SECTION 73 APPLICATION – VARIATION/REMOVAL OF CONDITIONS 2, 3, 5, 7, 8, 9, 11 AND 12 OF PLANNING PERMISSION REFERENCE 23/1142/FFU

DEMOLITION OF EXISTING DETACHED DWELLING AND CONSTRUCTION OF REPLACEMENT DETACHED DWELLING WITH GARAGE

FAIRFIELDS, PENNYPOT LANE, CHOBHAM, SURREY, GU24 8DJ

PROJECT No.: FPL2012  
DRAWING No.: PL01 / B  
SCALE @ A2: 1:200

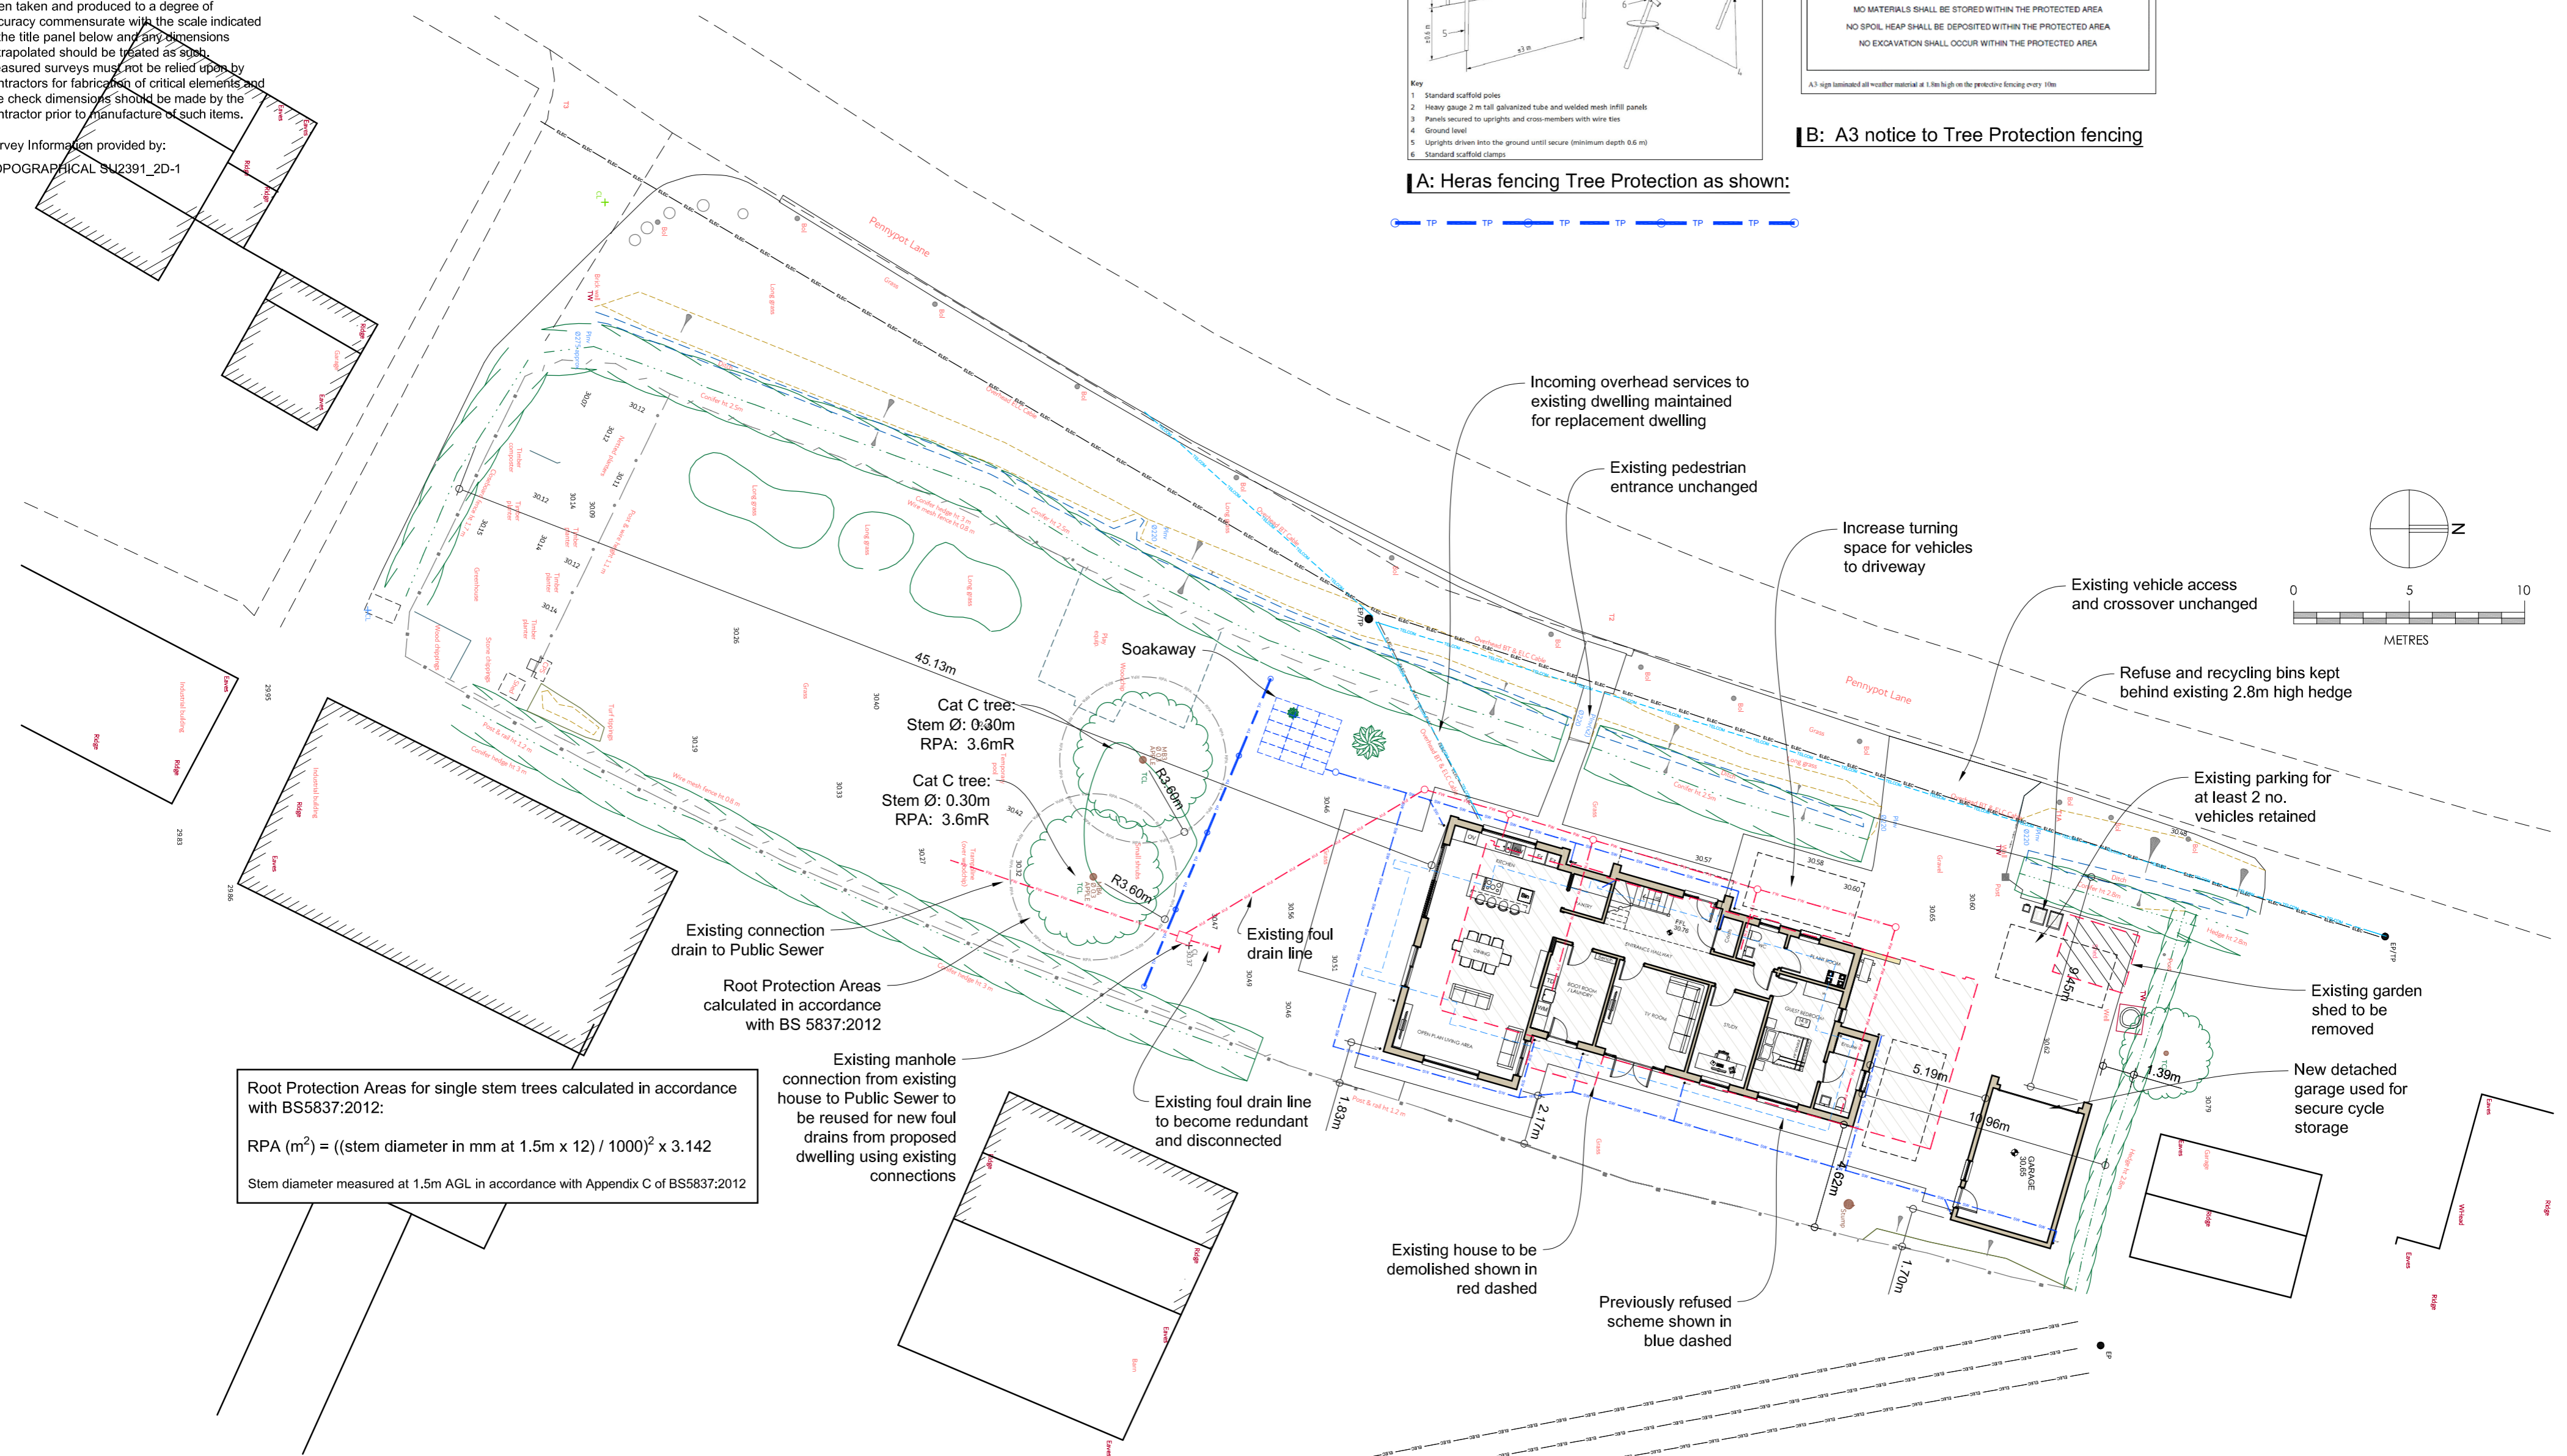
The first part of the application relates to the slight re-siting of the proposed detached garage building 1 metre further back into the site and closer to the rear boundary of the property. The separation to the rear boundary would be reduced from 2.7 metres to 1.7 metres.

This proposed change should be relatively straightforward given both the very modest change involved, its relationship to the neighbouring property to the north-east, and that it would provide some more manoeuvring space on the site frontage. In addition, the building would be less visible in views along the road.

The tree information and tree protection plan were included as part of the submitted Technical Site Plan Drawing PL01A.

In our view, the requirements of such a condition could simply be tied to the relevant approved drawing (reference PL01A (or PL01B if subsequently accepted by the Council) which shows the particulars of tree protection measures. This would be proportionate to the type of development involved. The wording of the condition could simply be revised accordingly.

Therefore, this application is accompanied by two revised drawings, being the Technical Site Plan (PL01B) and the Hard and Soft Landscaping and Proposed External Materials Plan

(PL06B). These drawings essentially show the proposed detached garage building in its re-sited position on the site.
